Hyde Park Hayes (HPH) Units 4 and 5, Millington Road – Transport Assessment and Travel Plan

I am writing to provide further information in response to comments received on the above from TfL and LB Hillingdon Officers. For ease, I have followed the headings used within TfL's responses.

Ground Floor Plan

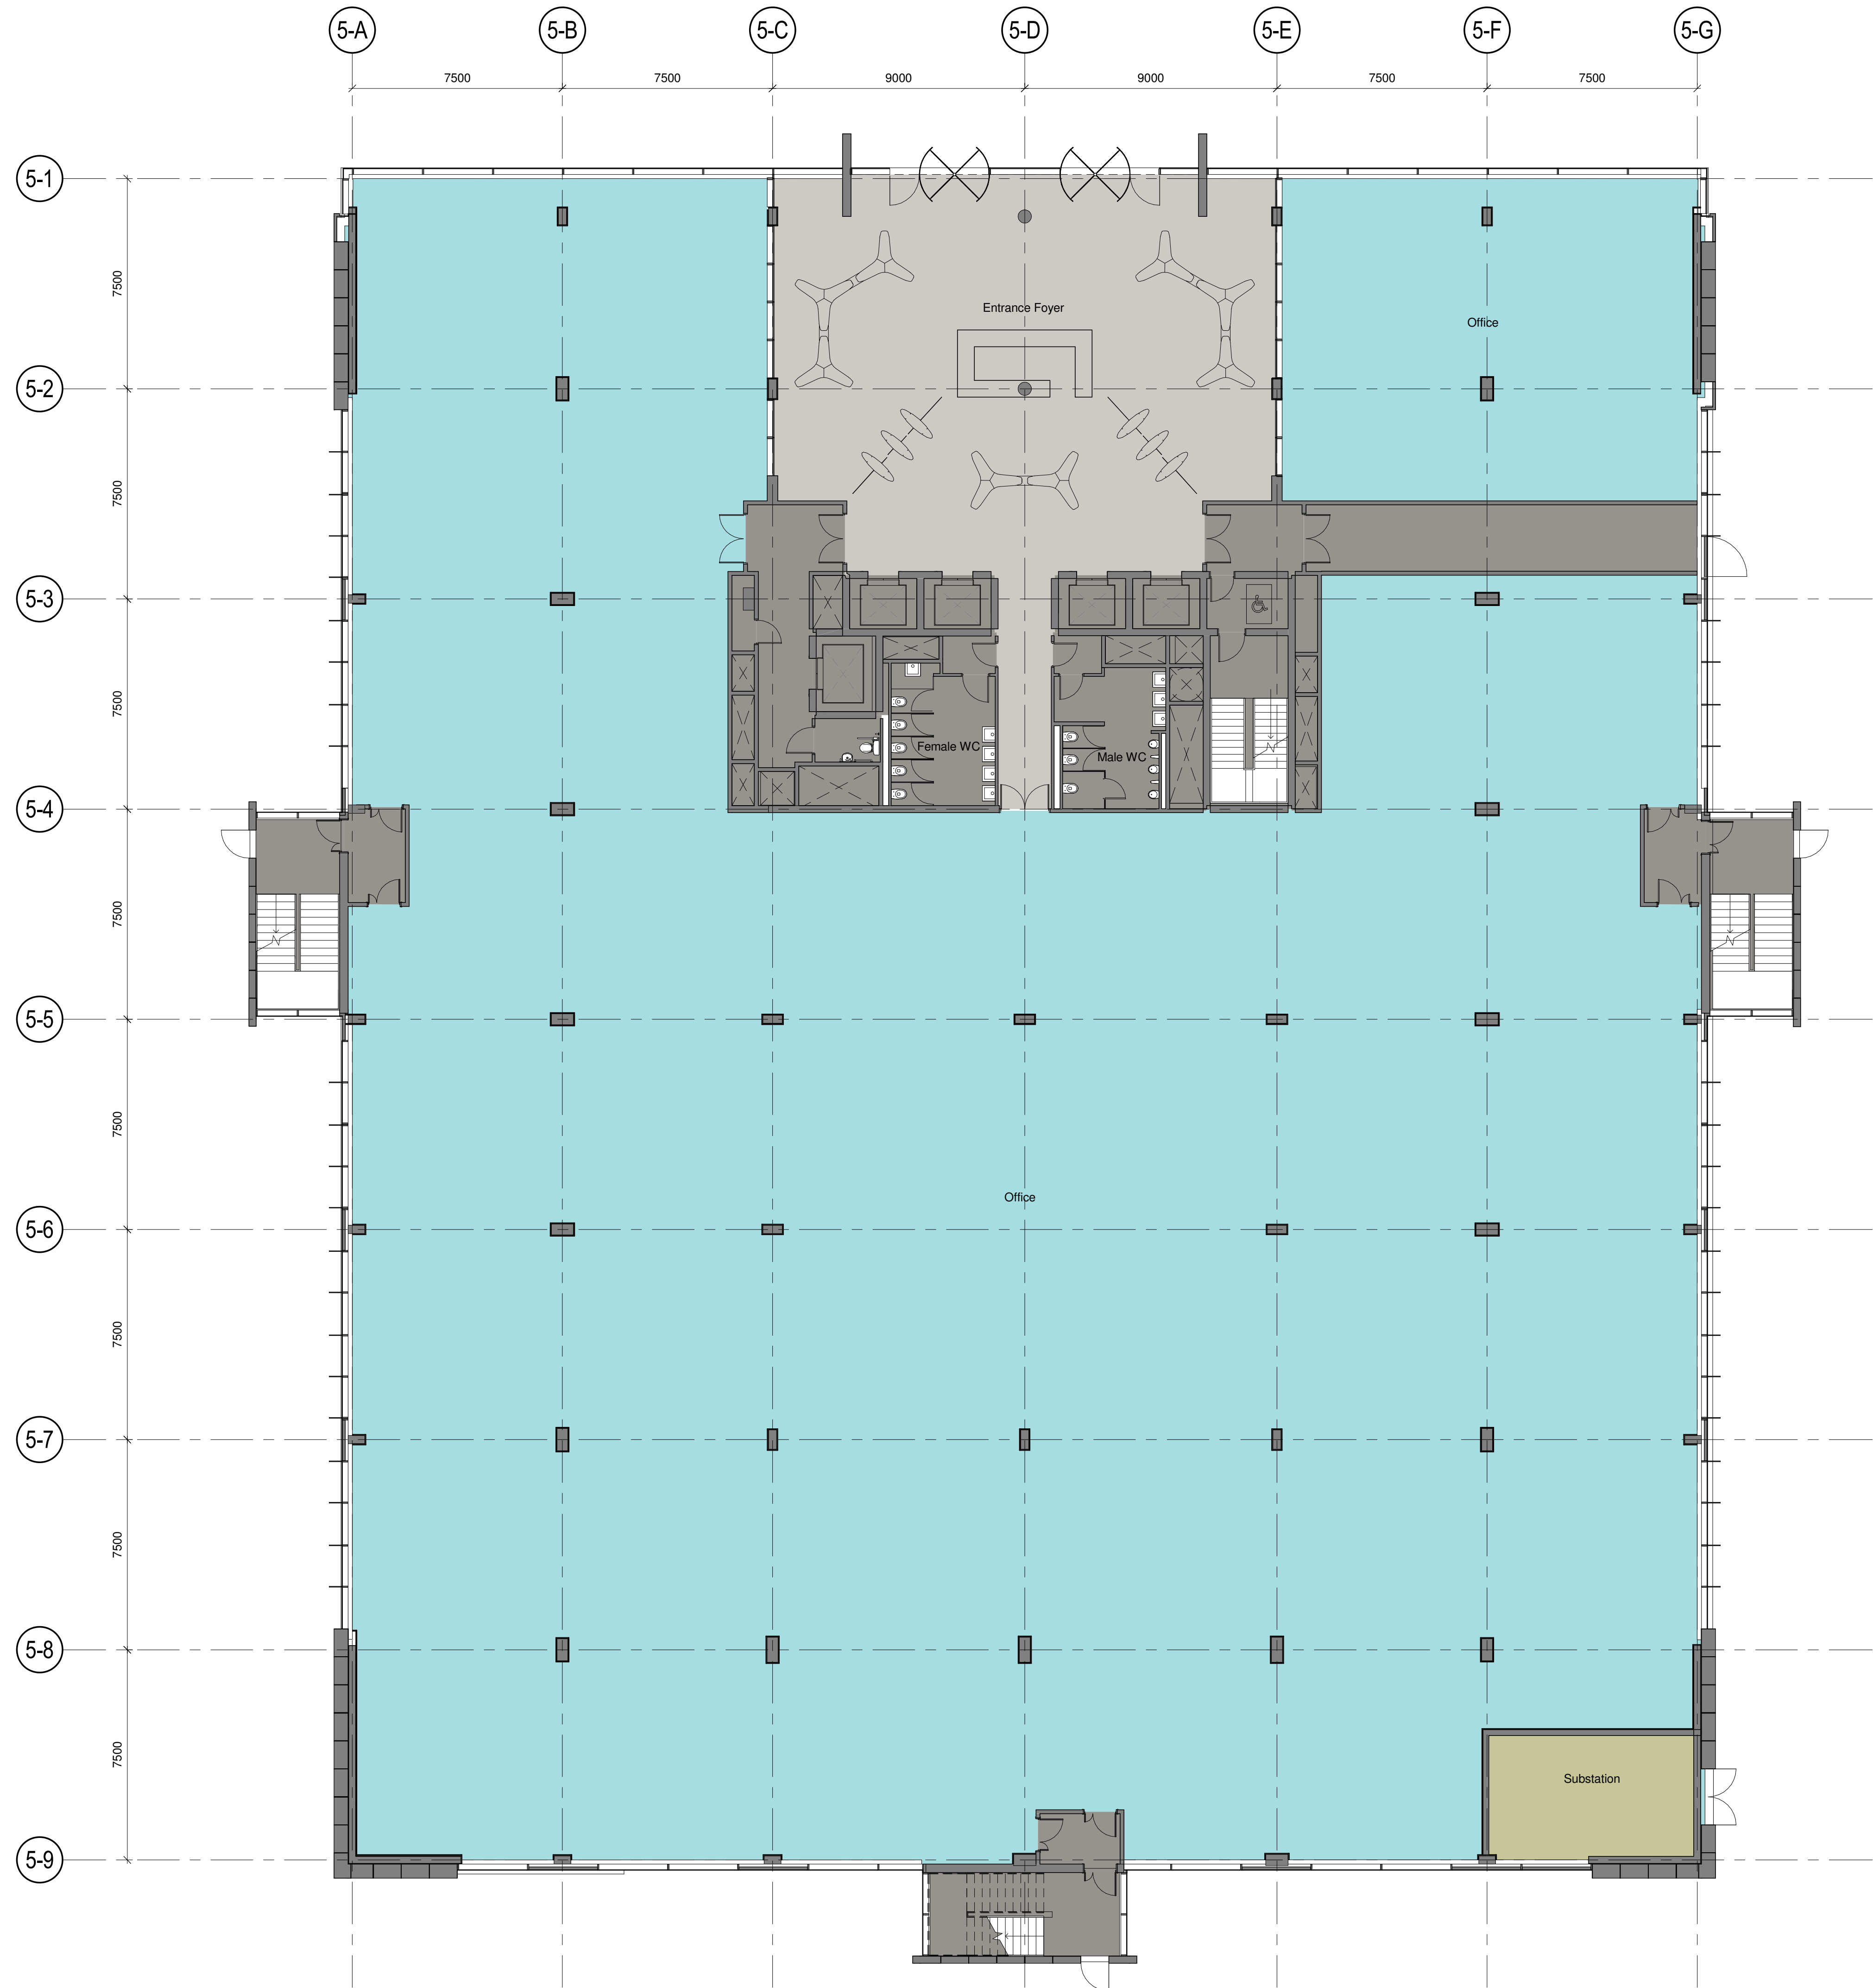
TfL acknowledge that the London Plan policy for B1 uses allows for parking in the range of one space per 100sqm to 600sqm. In this location they suggest that one space per 300 sqm would be appropriate. We do not agree with this view. The Outer London location of the site means that all existing B1 space in the area already has higher level of parking than are being proposed, which would make the development less attractive to occupiers, and endanger the delivery of this employment generating scheme, which is key to the regeneration and improvement of Hayes. LB Hillingdon's maximum parking standards for B1 use are one space per 100 sqm.

However, in light of TfL's comments, and as part of the evolution of the scheme design, some changes to car parking numbers have occurred, with a reduction of 18 spaces in total from both sites (16 from HPH5 and 2 from HPH4). This results in an overall provision of 194 spaces for both sites. The average provision across the two sites is therefore one space per 107 sqm. This is within LB Hillingdon's maximum standards and within the maximum standard allowable within the London Plan.
